Subject: RE: Planning Consultation on: A/227/21/OUT

Engineers Comments Regarding Surface Water Drainage

Application No: A/227/21/OUT
Registered: 3rd November 2021
Site Address: Wilmington Arundel Road Angmering BN16 4ET
Grid Reference: 506710 105511
Description of Works: Outline application with all matters reserved (except access) for the erection of 7 No residential dwellings, vehicular & pedestrian access. This application is a Departure from the Development Plan.

Drawing No.	D1991-PL301	Rev.	-
-------------	-------------	------	---

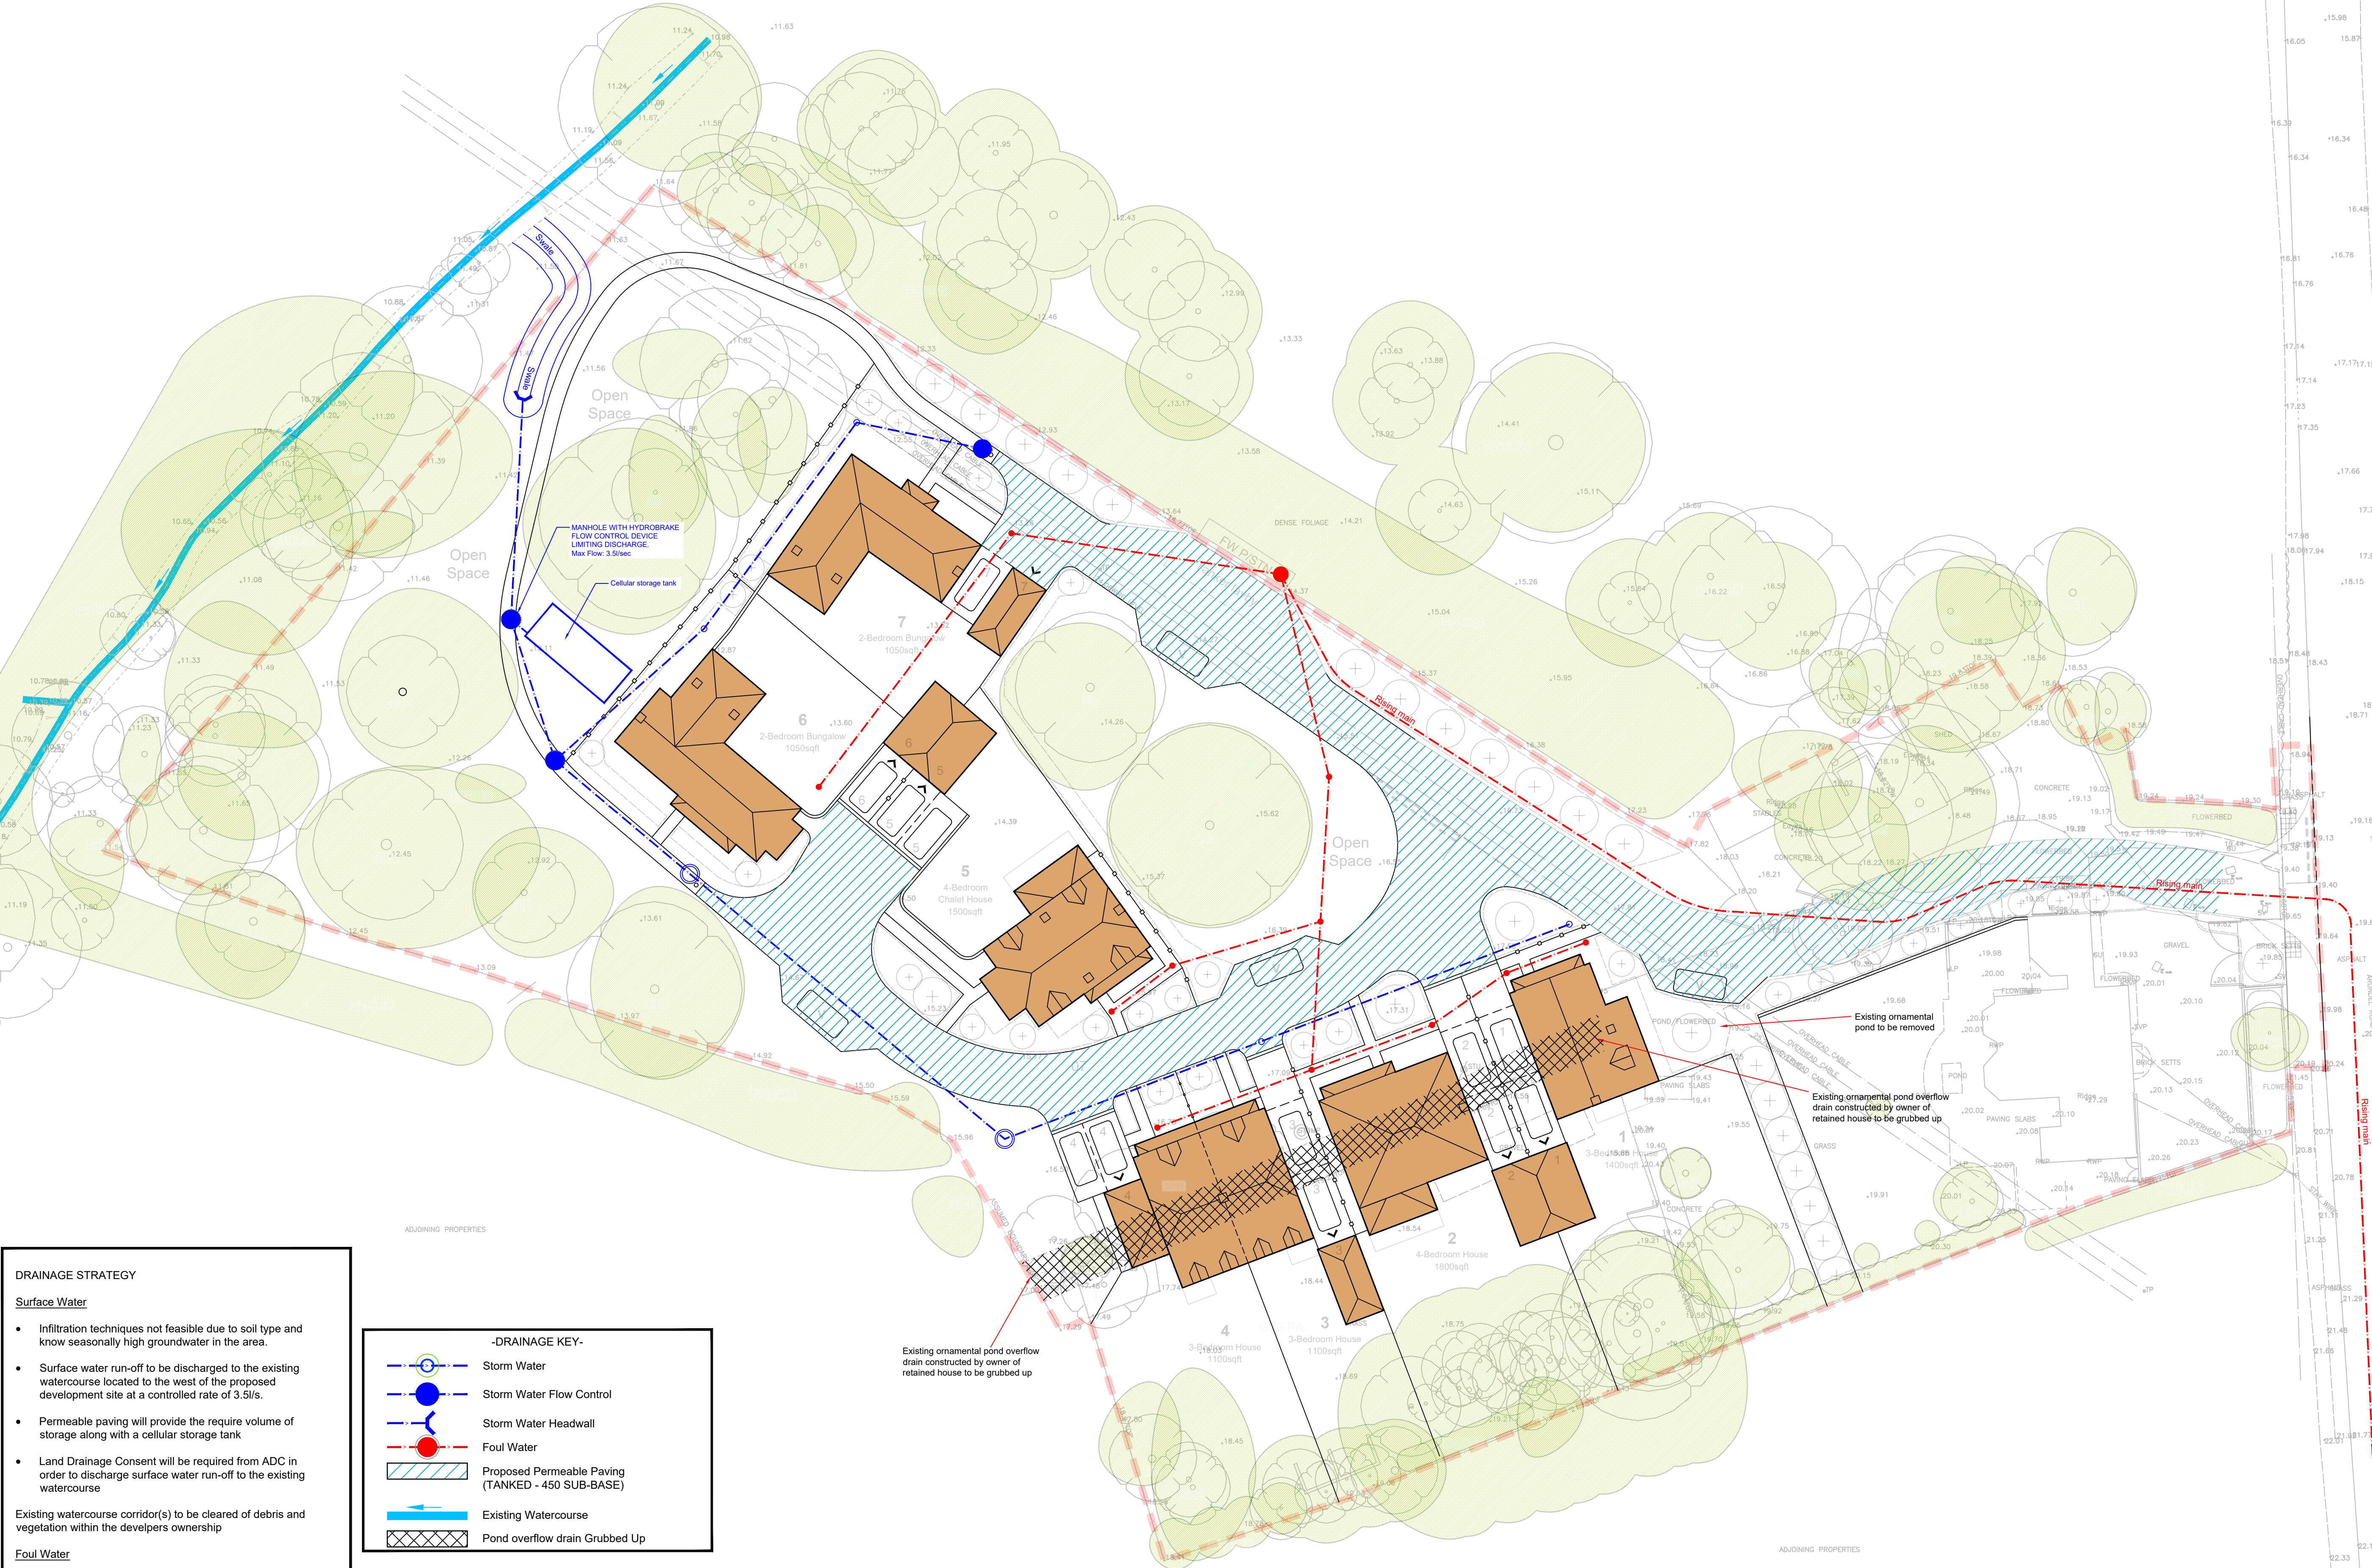
The drainage strategy also appears to contradict itself. Within the text, the strategy states that it is proposed to construct a 'seepage trench' into which runoff will be discharged. The strategy appears to be to allow the trench to fill and then spill overland towards the watercourse. The same feature is shown on the Arboricultural Impact Assessment Tree Protection Plan. This is in contrast to drawing D1991-PL301 which shows surface water being discharged at a restricted rate to a swale which conveys water to the watercourse north of the site boundary.

We would not consider approving a strategy which allows unrestricted flow of surface water to travel overland through third party land to the watercourse. If an overland conveyancy feature like the swale is proposed then the text and Tree protection Plan need to be adjusted to make this clear. Please consult the Tree Officer regarding the placement of a pipe, swale, or seepage trench within the root protection areas that are shown.

Therefore I wish to lodge a holding objection to the application. In order to overcome my objection the inconsistency between the documents must be rectified. Evidence of agreement from the third party landowner to a pipe/ditch/swale on their land connecting the surface water drainage system to the north must also be provided. In addition I would need to see a worst case drainage layout, with a discharge rate of 2l/s, which clearly shows how water could be conveyed to the watercourse without incurring on any tree root protection areas, or agreement from our Tree Officer that any necessary incursion may be acceptable.
